DRB Application No.: 0700276
Project Name: Landscaping 21A TRUS
Agent: Alvin H. Hageman

Project # 1003121
Phone No.: 249.3378

14. Project # 1003121
07DRB-00276 Minor-Prelim&Final Plat
Approval

STEWART INGHAM agent(s) for ZIA TRUST INC request(s) the above action(s) for all or any portion of Tract(s) 19, M.R.G.C.D. MAP 36 (to be known as **TRACTS A & B, LANDS OF ZIA TRUST**) zoned R-1 located on FORAKER NW between LOS TOMASES NW and 8TH ST NW containing approximately 1 acre(s). [REF: 07 DRB00135] (H-14) **THE PRELIMINARY AND FINAL PLAT WAS APPROVED WITH FINAL SIGN-OFF DELEGATED TO UTILITIES DEVELOPMENT TO ADD BENEFICIARY AND MAINTENANCE LANGUAGE FOR PRIVATE WATER AND SEWER SERVICE LINES AND ACCESS EASEMENT AND TO PLANNING FOR AGIS DXF FILE AND TO RECORD.**

SURVEYOR'S CERTIFICATE:
 State of New Mexico } S.S.
 County of Bernalillo }

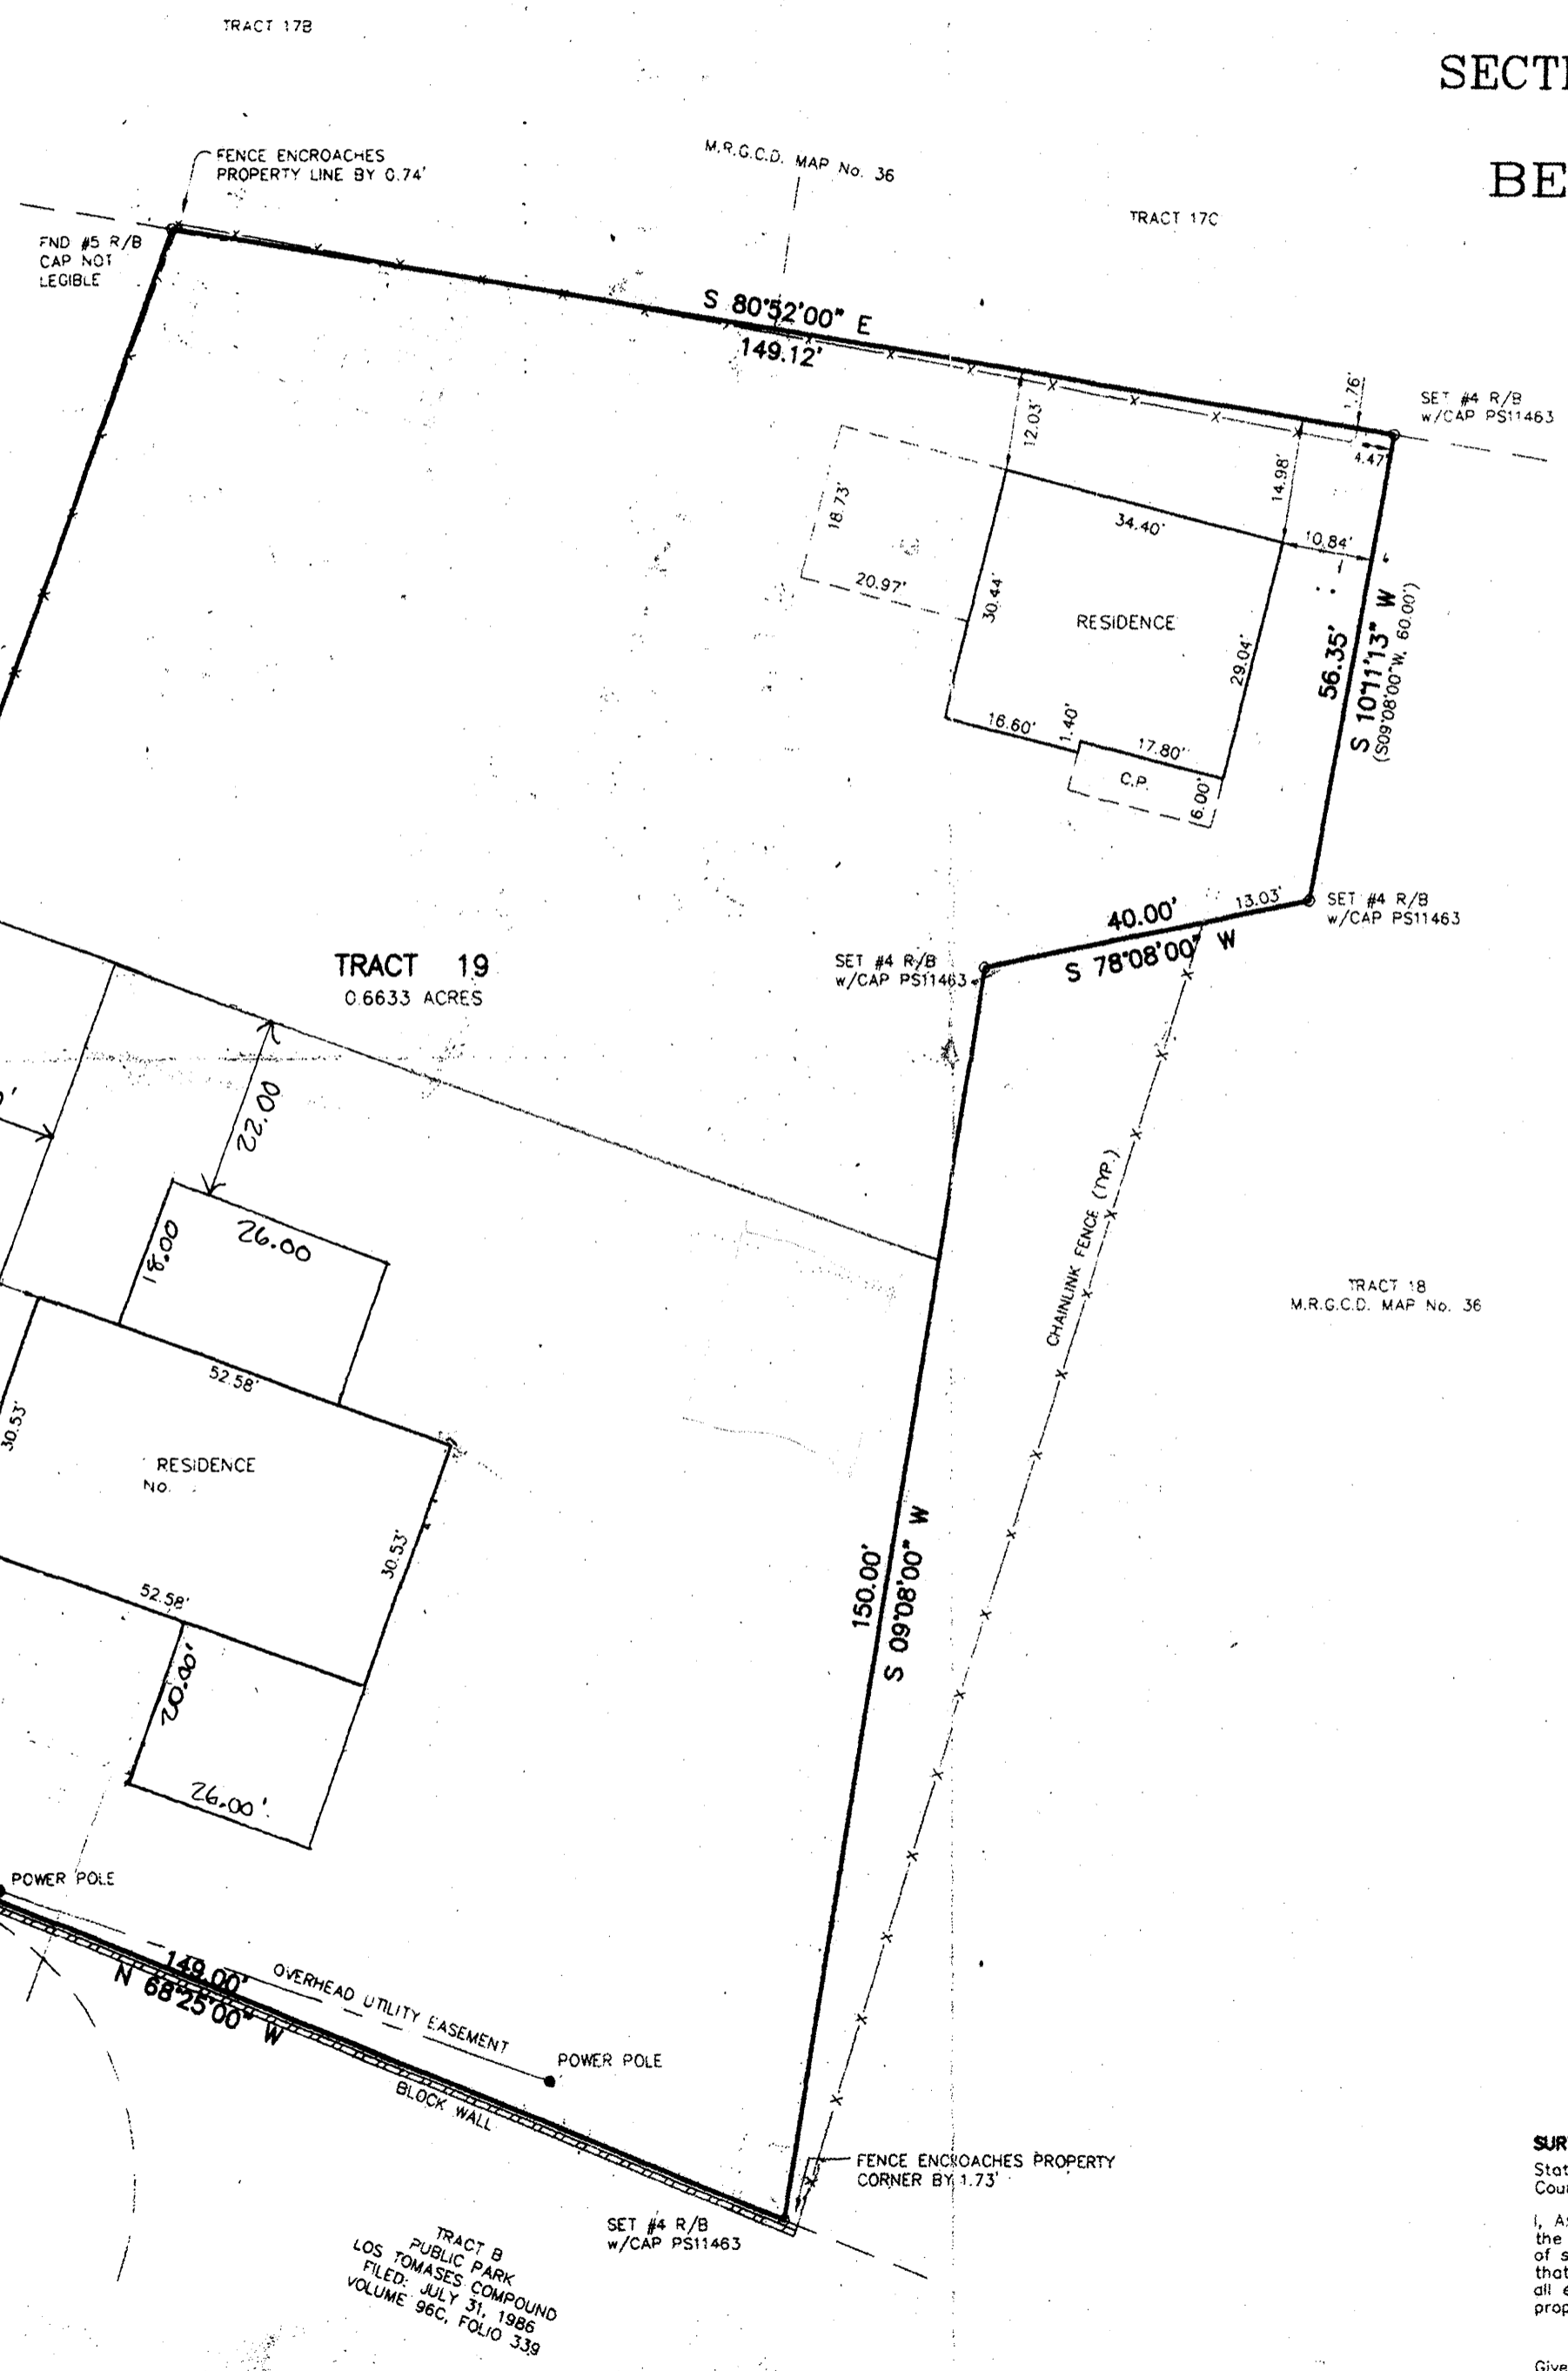
Only one residence is allowed per lot in R-1 Zoning.

Be sure to follow the required R-1 setbacks.

It's unclear where the lot lines are.

Need cross-lot drainage easements.

No.	Comment
(1)	NEED TO SHOW ADJOINING LOTS THAT HAVE ACCESS TO EASEMENT FROM LOS TOMASES DR. - NEED TO SHOW THIS EASEMENT & WIDTH
(2)	CROSS ACCESS EASEMENT WILL BE NEEDED BETWEEN LOTS 2 & 3
(3)	DUE LOT 1 TAKE ACCESS USING THE 22' PRIVATE EASEMENT?

THE PURPOSE OF THIS PLAT IS TO DIVIDE TRACT 19 INTO 2 TRACTS AND GRANT ANY EASEMENTS AS SHOWN.

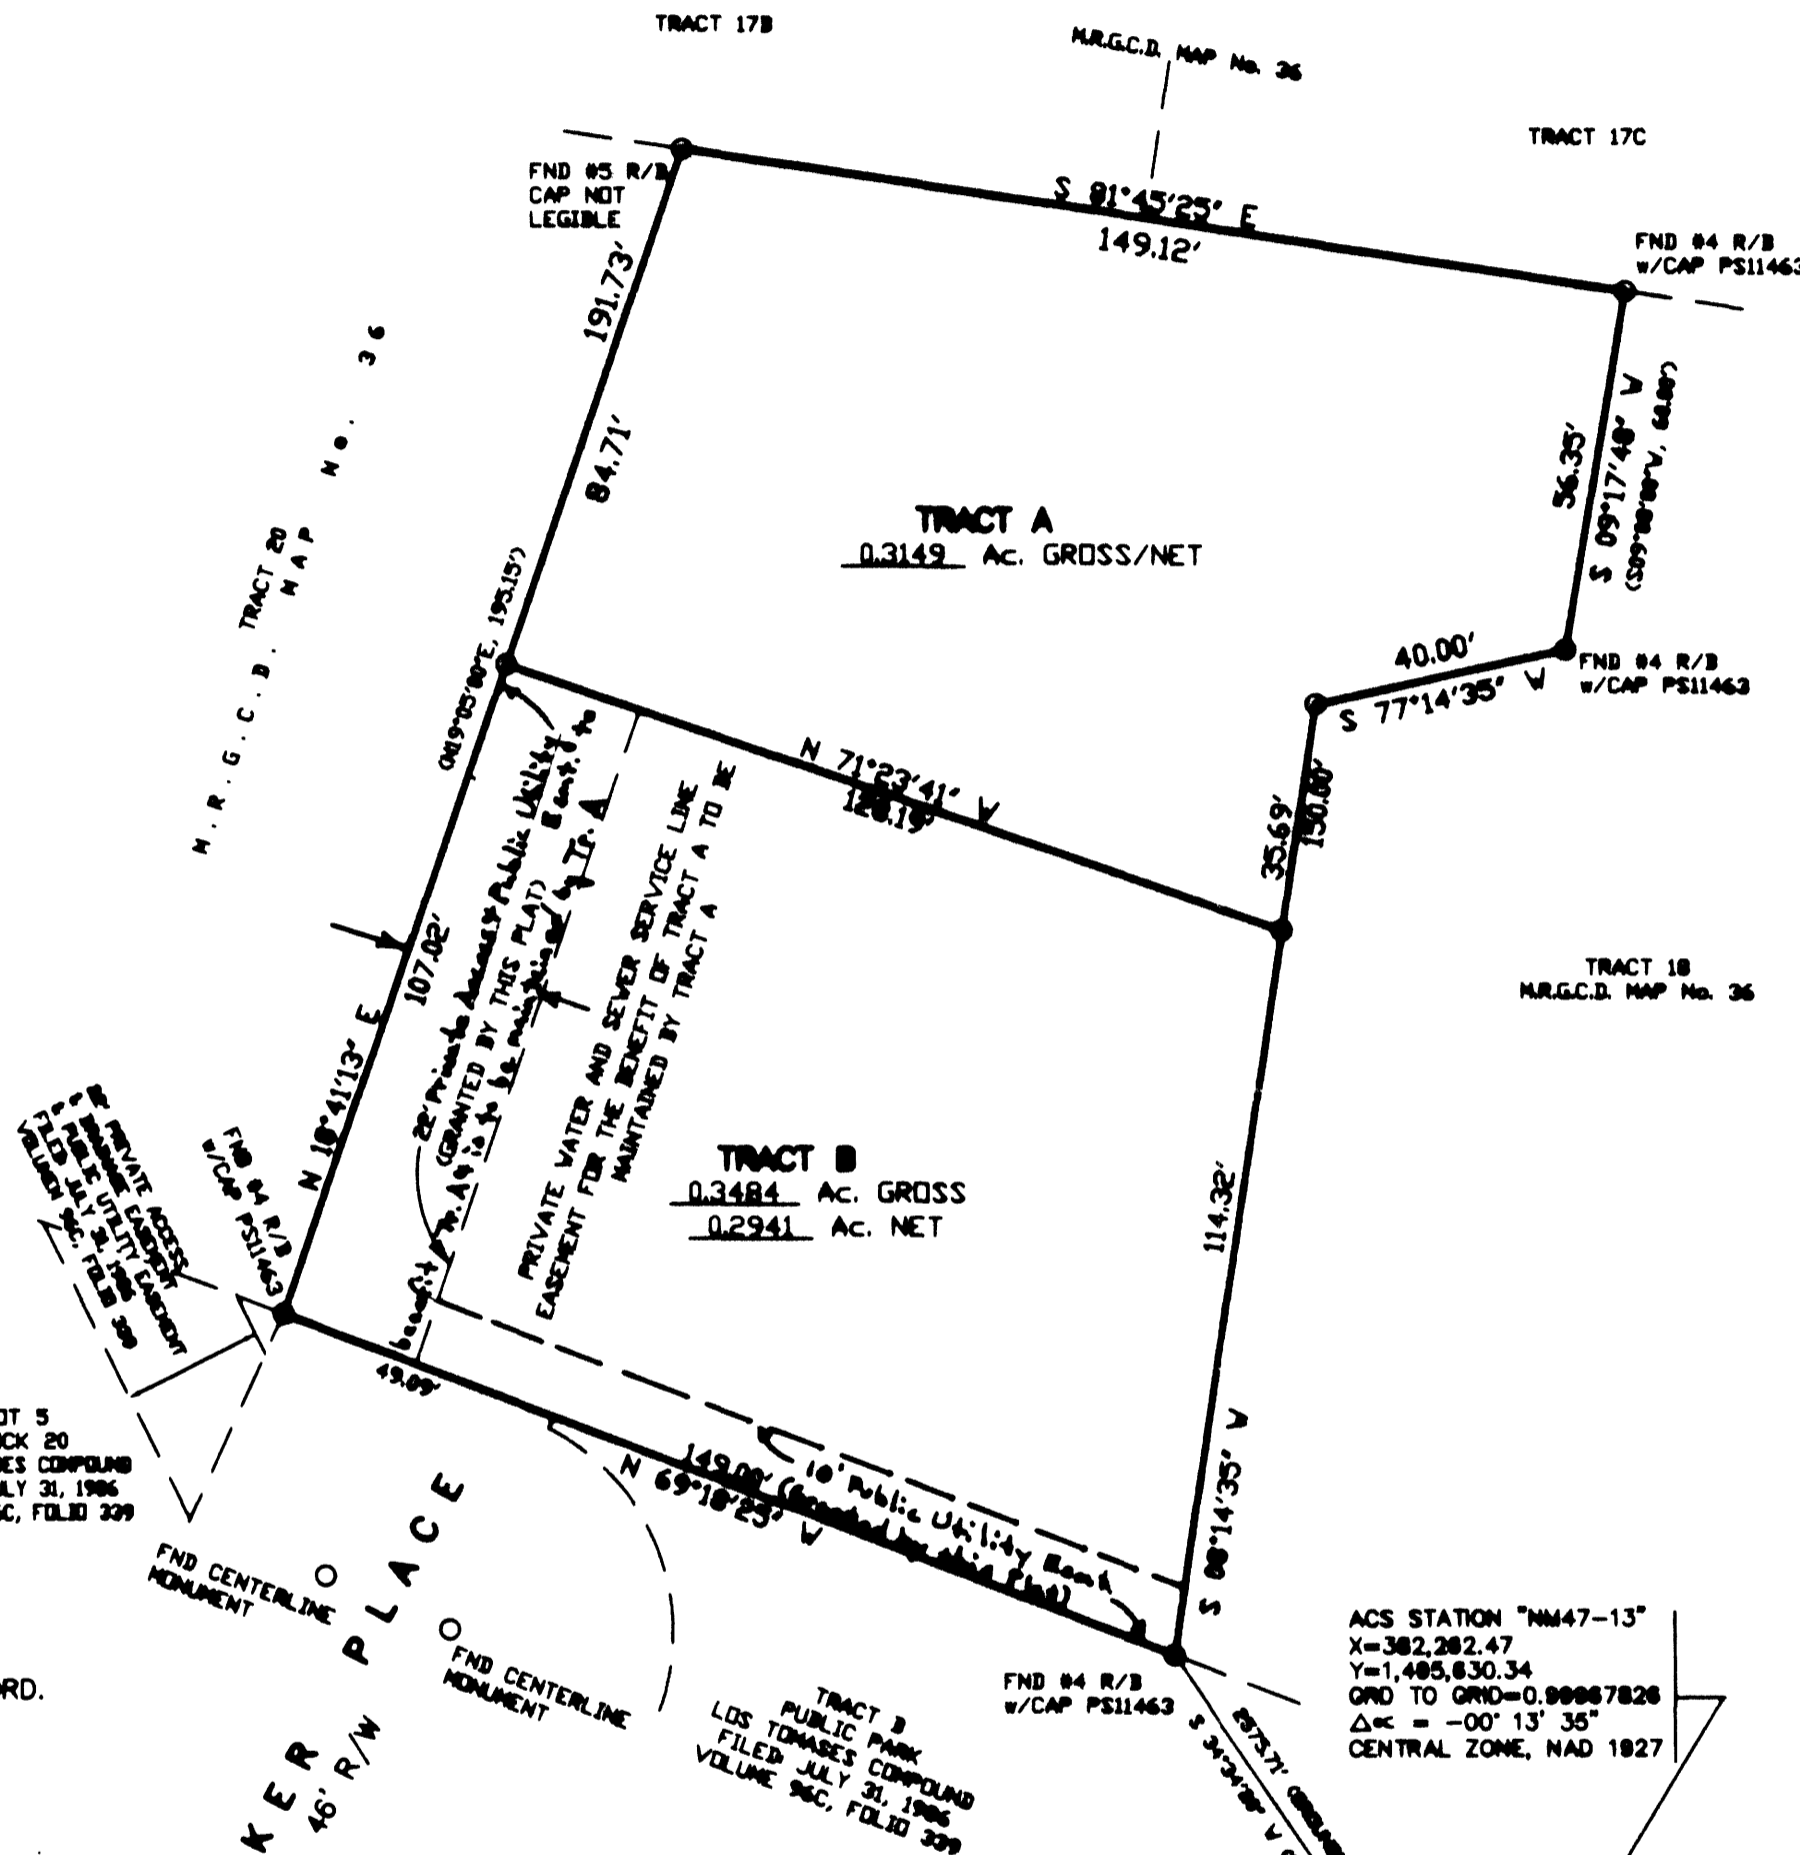
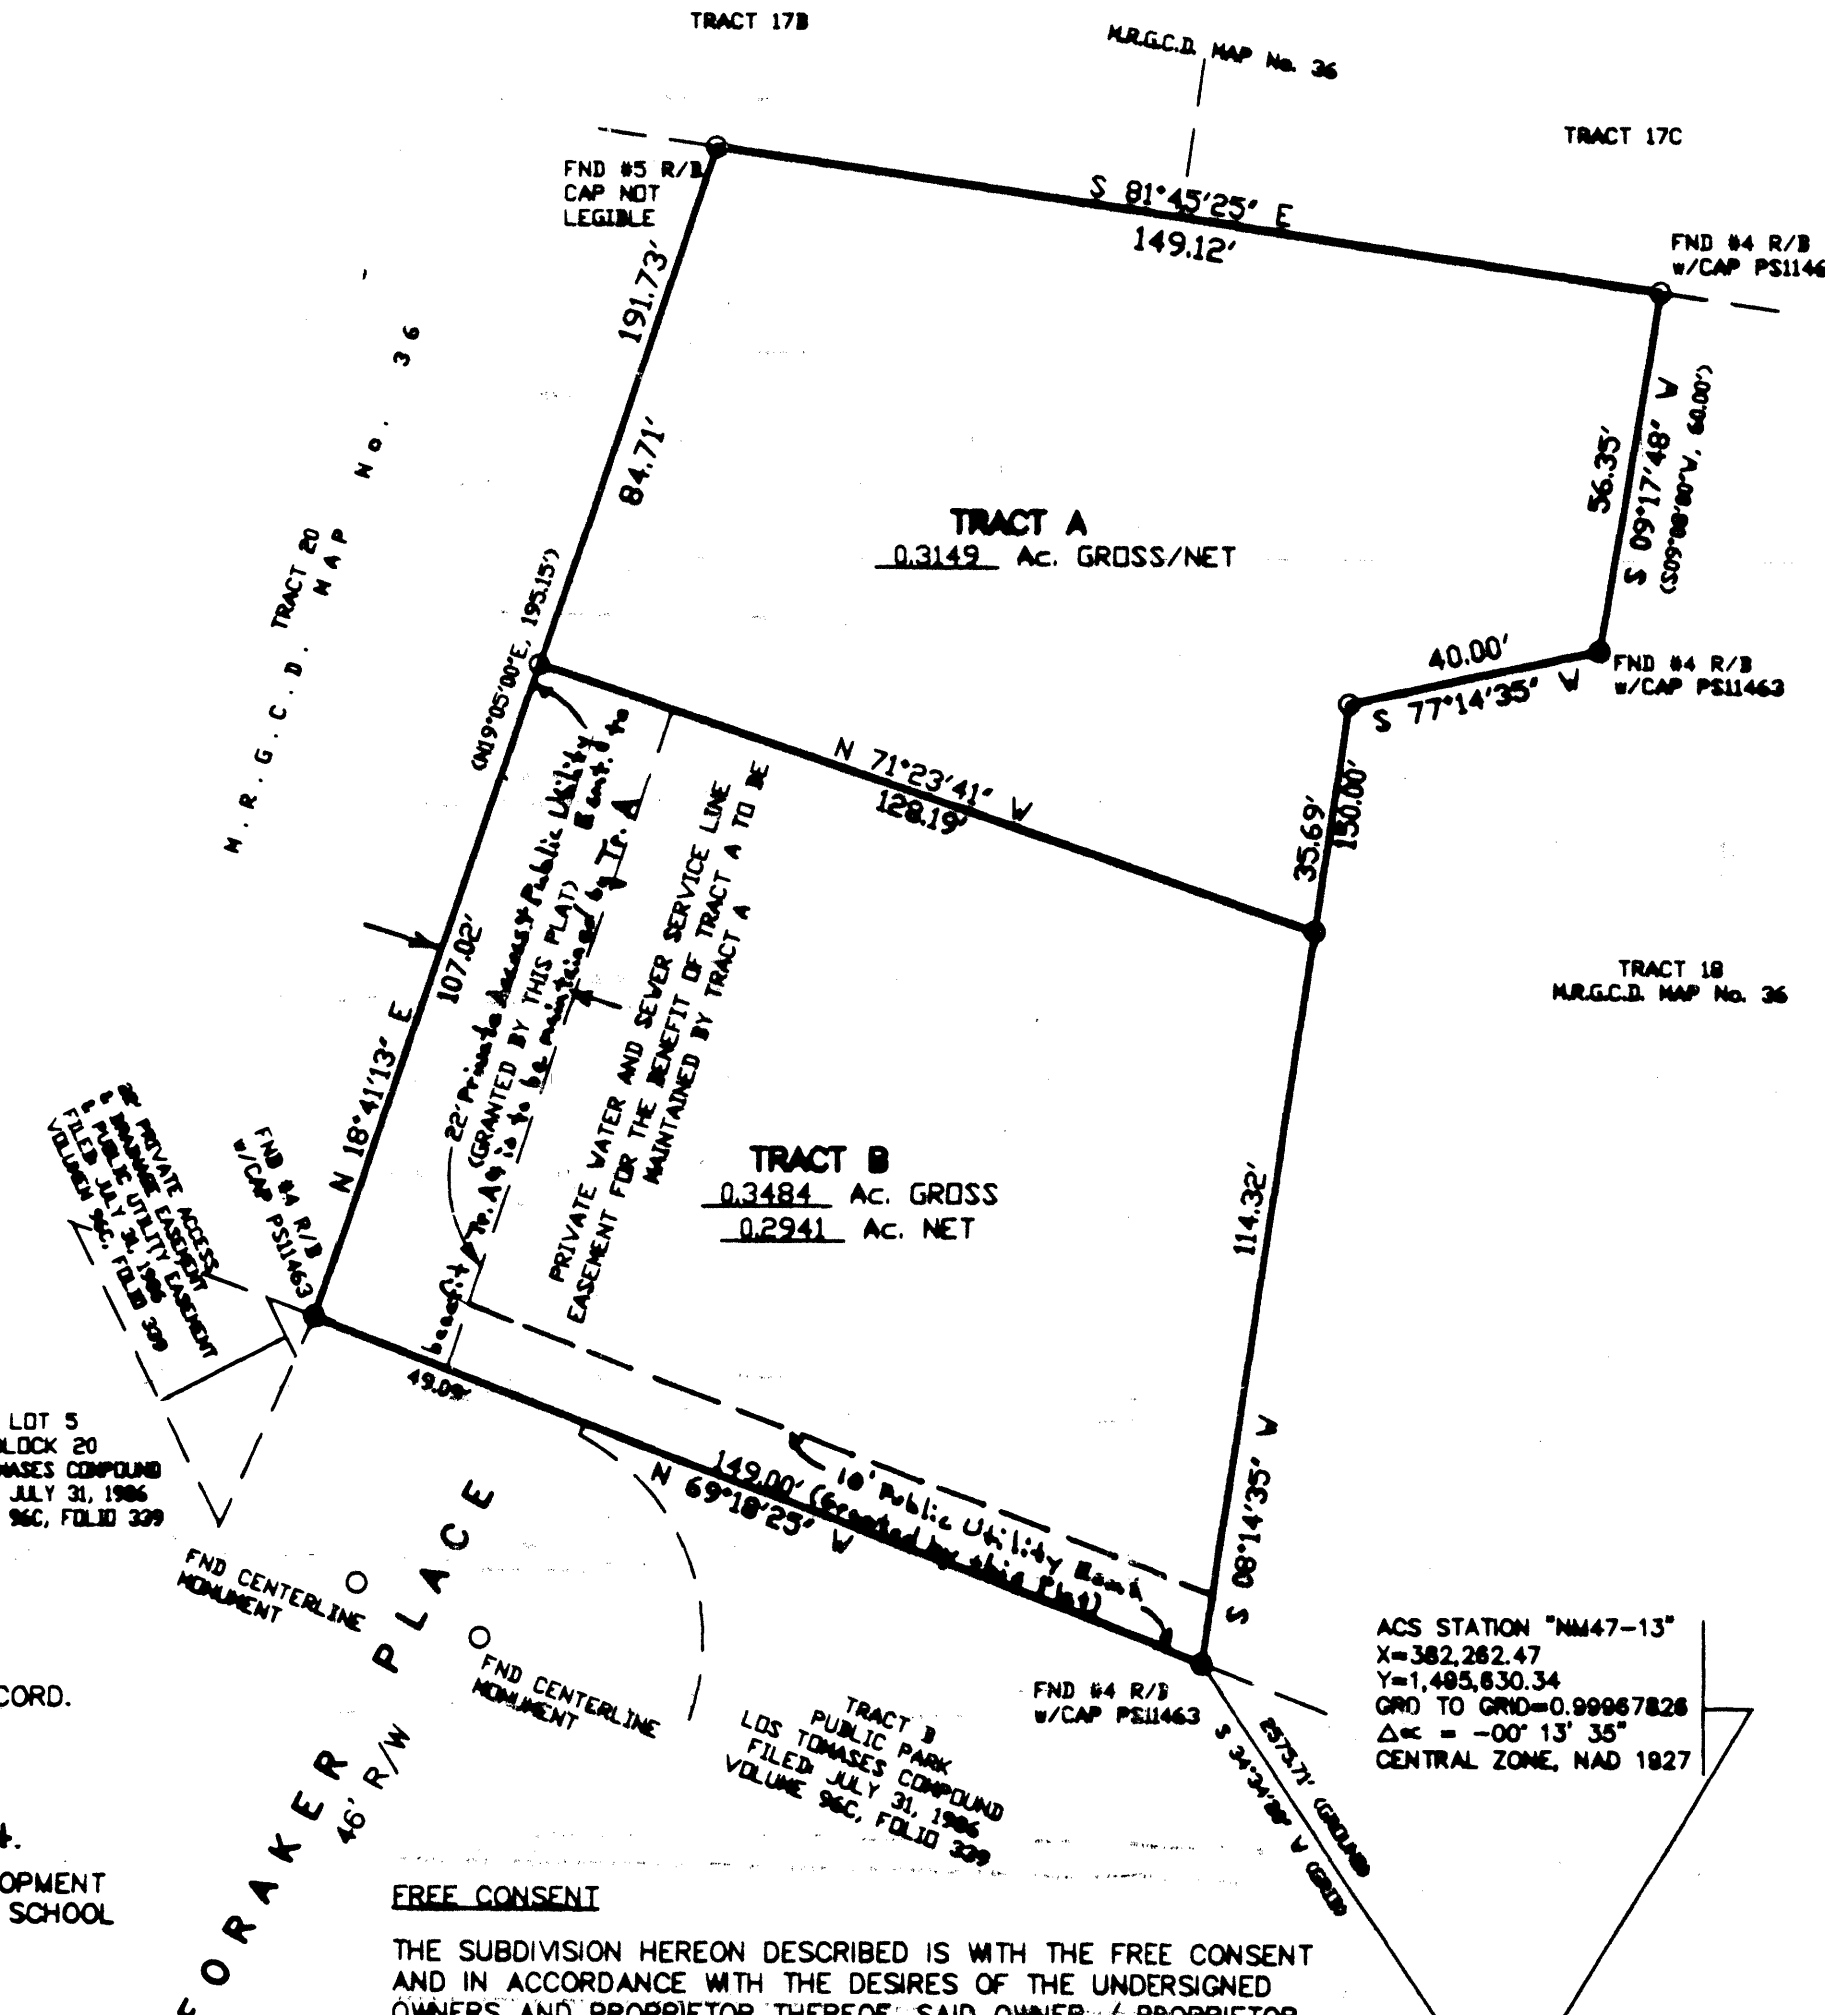
UTILITIES: add beneficiaries & Maintenance language for private water/sewer service lines and access easement

A cross lot drainage easement is required.

AGIS dxf is not approved.

<u>No.</u>	<u>Comment</u>
1)	A copy of the 22' private access easement is needed.
2)	A copy of the plat to the south is also needed.
3)	Is there a drivepad on the Foraker cul-de-sac?
